Community Garden (Evergreen Cemetery)

From: Tom Saucier [TSaucier@mail.sytdesign.com]
Sent: Monday, April 05, 2010 8:54 AM
To: Kwoka John J SOSB; Anne D. Weigel; John Kwoka
Subject: Brentwood Farms Community Garden

Per your request we have undertaken an review of the stormwater magement, report, plans, and calculations, prepared by Sebago Technics, dated March 2010, for the Brentwood Farms Community Garden development located northerly of your property at 92 Hamblet Avenue. Based upon that review, we offer the following comments for your consideration.

**PRE-DEVELOPMENT STORMWATER PLAN**  
 OF:  
**BRENTWOOD FARMS COMMUNITY GARDEN**  
 AT EVERGREEN CEMETERY, BRENTWOOD STREET  
 PORTLAND, MAINE  
 FOR:  
**DEERING CENTER NEIGHBORHOOD ASSOC.**  
 14 HILLIS STREET  
 PORTLAND, ME 04103

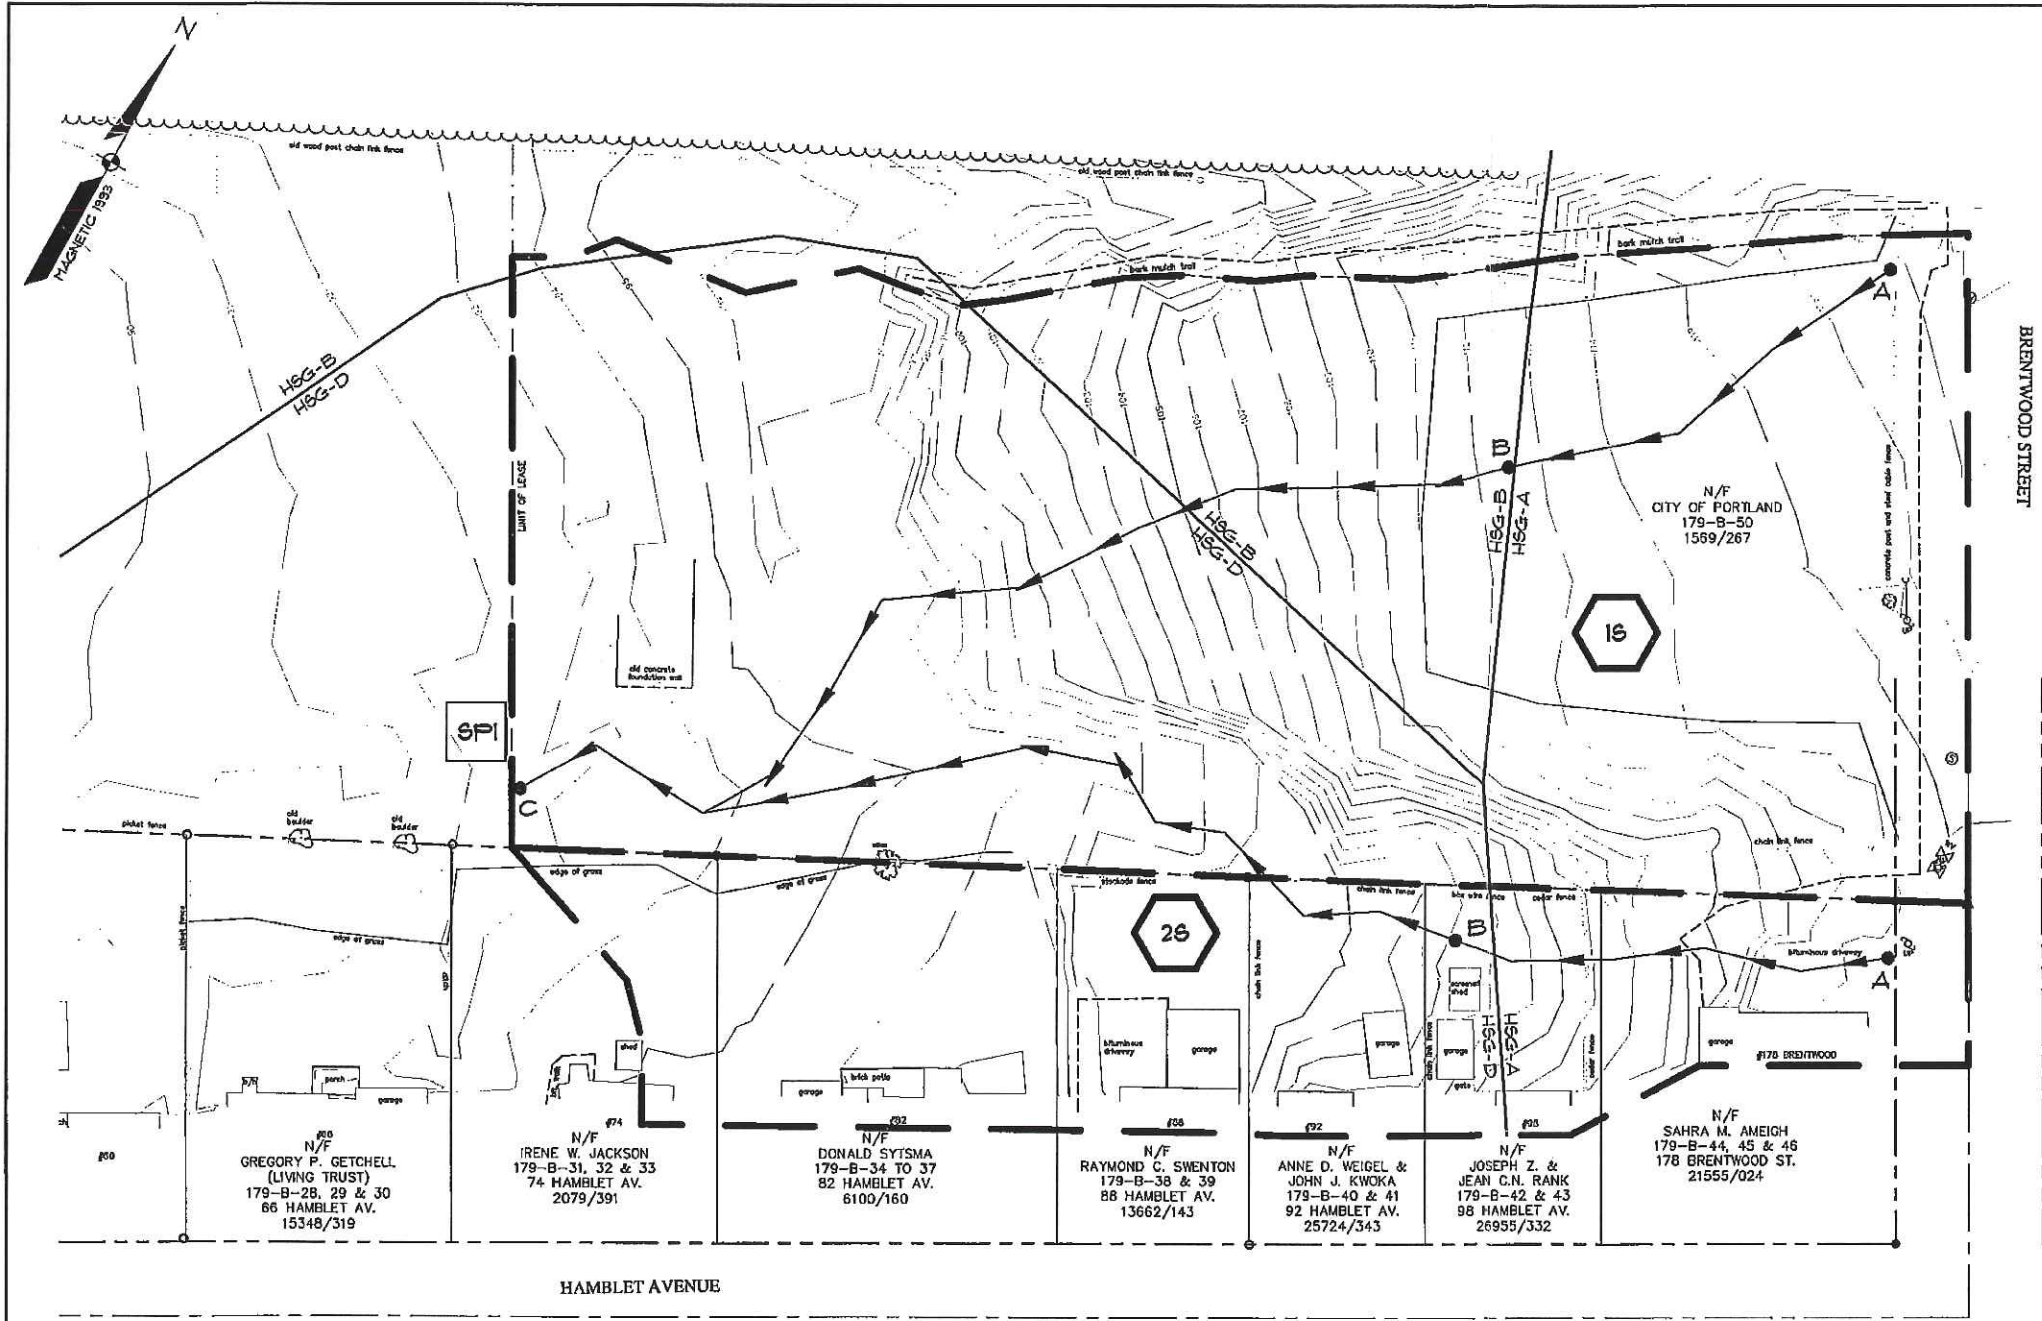
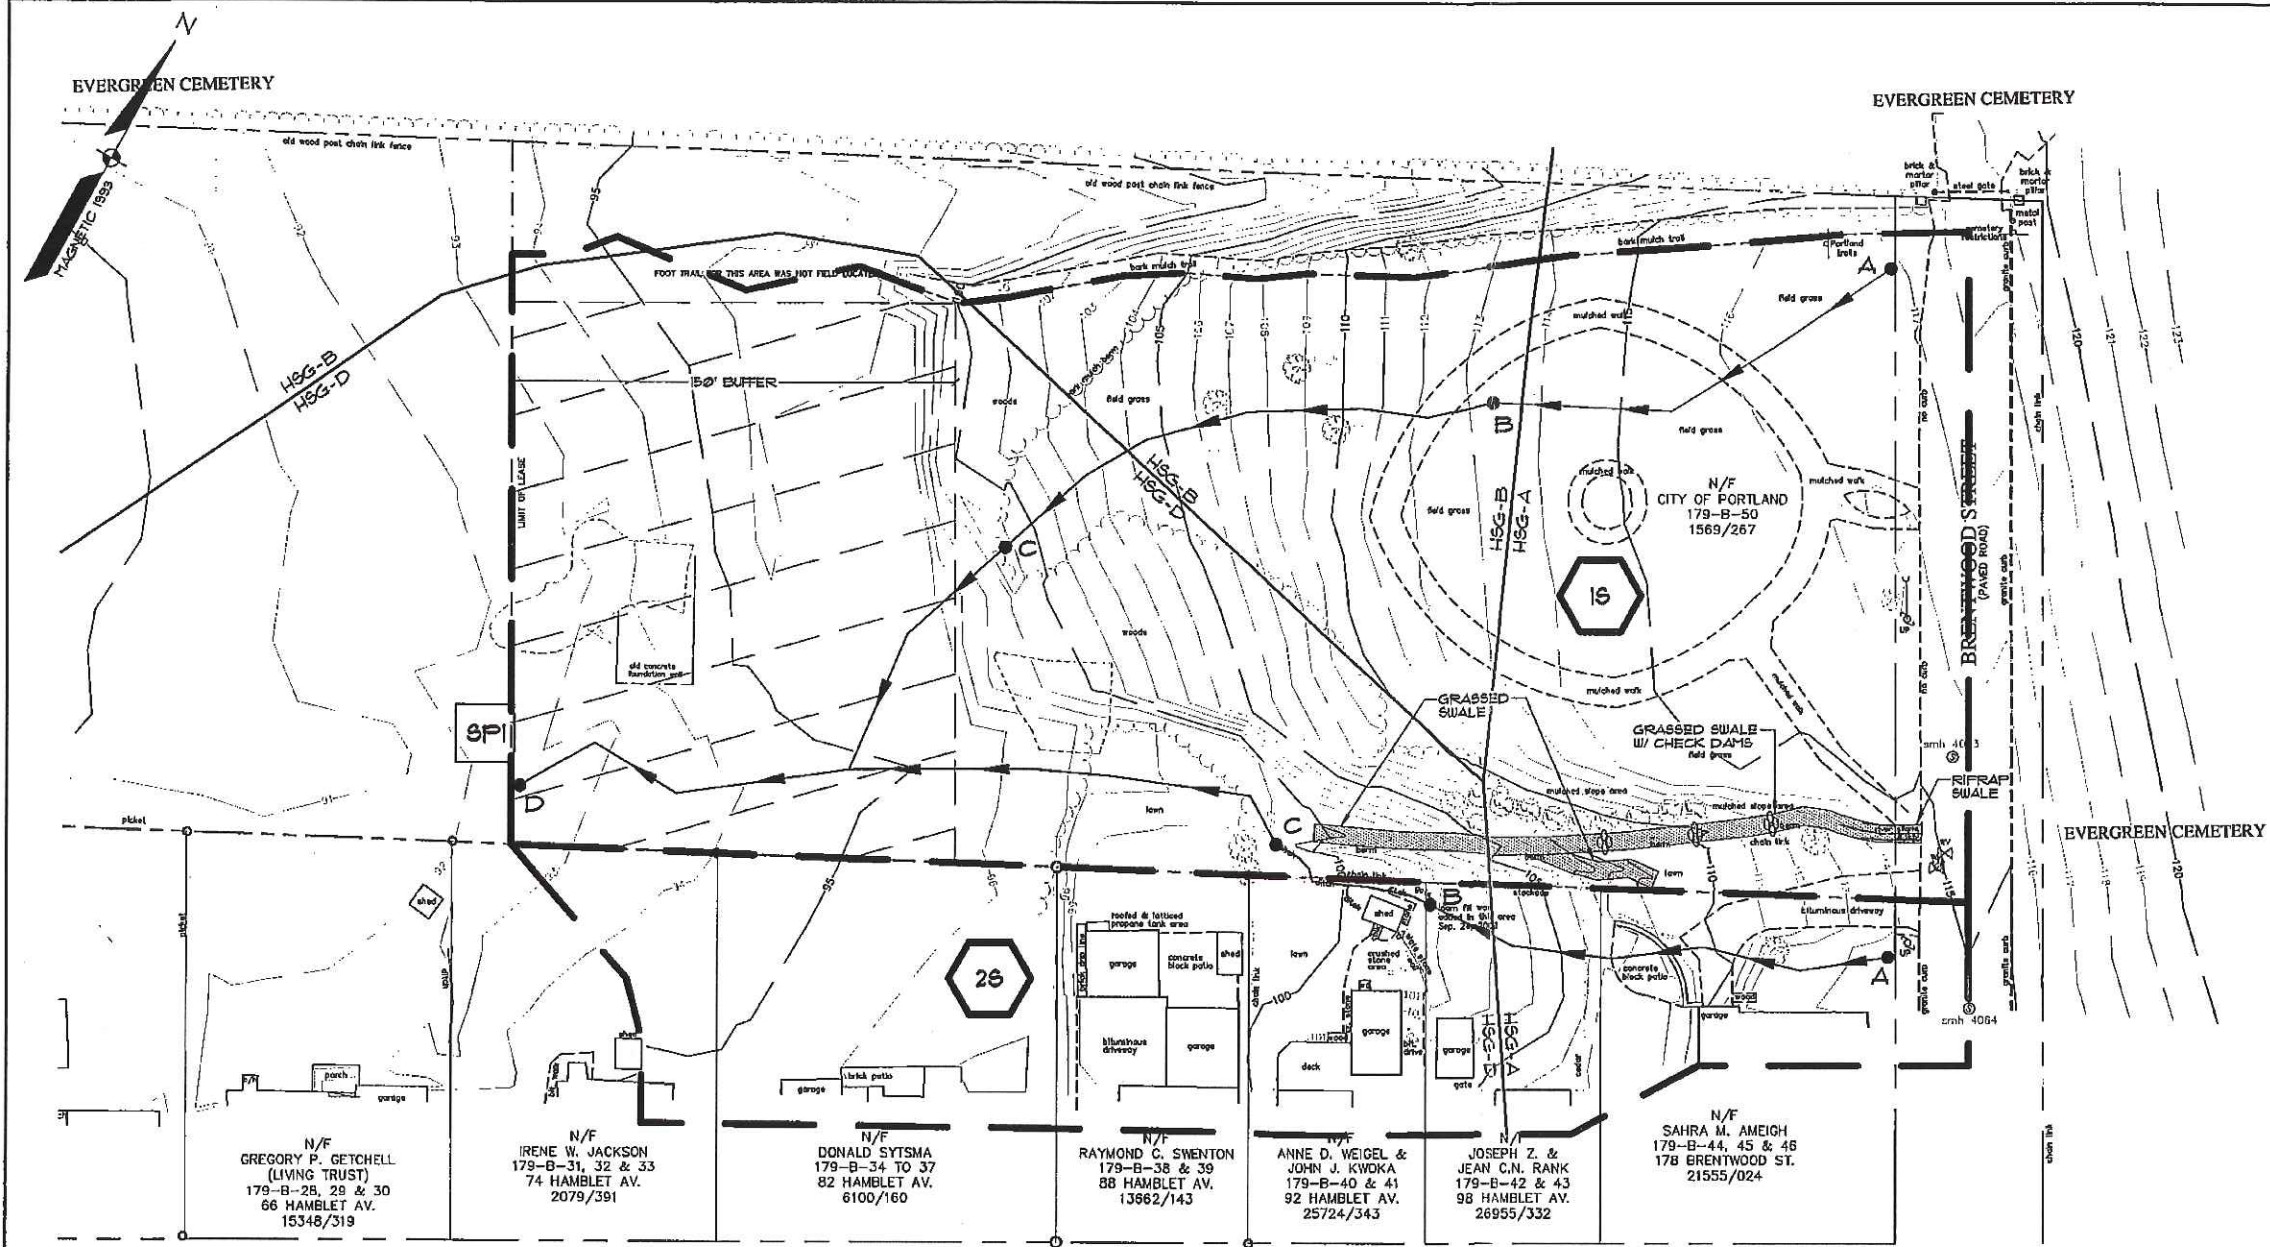
The study utilized an analysis point located at a distance of more than 250 feet downgradient of your property, to arrive at a conclusion that there would be no increase in the rate of runoff at that point, which does nothing to answer the question of whether the development has impacted your property.

A more appropriate analysis, if they wish to address your concerns, would be to model the runoff conditions with a study point at the northwest corner of your property where the ponding of runoff from the site occurs, and also to more closely examine existing and pre-existing conditions on and near Brentwood Street, which is the area contributing runoff to your yard.

An example of the first is the boundary between SC 1S and 2S, which follows a property line, instead of the topographic subwatershed divide.

The second includes the time of concentration path for SC-1 crossing this boundary into SC-2.

An example of the third item is the use of a runoff curve number for the garden areas, legumes, that TR-55 clearly indicates is intended to be used for large scale agricultural lands, for close seeded or broadcast legumes. We question whether that is appropriate for the garden plots, which we expect would be bare in the late fall and early spring, when we generally experience the significant rainfall events. Further, we noted that the curve number utilized for the mulched walking paths on the site did not change for each hydrologic soils group, even though the paths are located within each soil type area. It is also unclear what the basis for the mulch curve number is, as the one utilized would be similar to a wooded cover condition in type B soils. It seems that this might be inaccurate; to assume a devegetated path, covered with mulch and subject to continual foot traffic would have runoff characteristics similar to wooded areas. Also, the plan calls for unvegetated mulched slopes, which should be included in the analysis if they were not.

We also noted that the report indicates that the pre-development cover types were "based on the activities that had previously occurred in the dumping area." We are unsure of the reason for this, or how one can simply speculate from this statement that the cover type should be modeled as poor grass cover, which indicates less than 50% cover. Recent aerial photography indicates that the cover on the site was fairly consistent grass cover (similar to the cemetery) with some walking trails or paths meandering through the grassed areas. It seems that a more appropriate curve number would be for grass cover greater than 75%.

Another conflict noted, is it appears the total area of each soil group in subcatchment 1S varies between pre and post development conditions, which would not be expected.

An additional observation is that the 1994 topographic plan indicates that runoff from half of Brentwood Street flowed across the undeveloped site. Current topography indicates that "gutter" flow occurs from north to south along Brentwood, with runoff from the easterly portion of the garden site and from half of Brentwood Street now
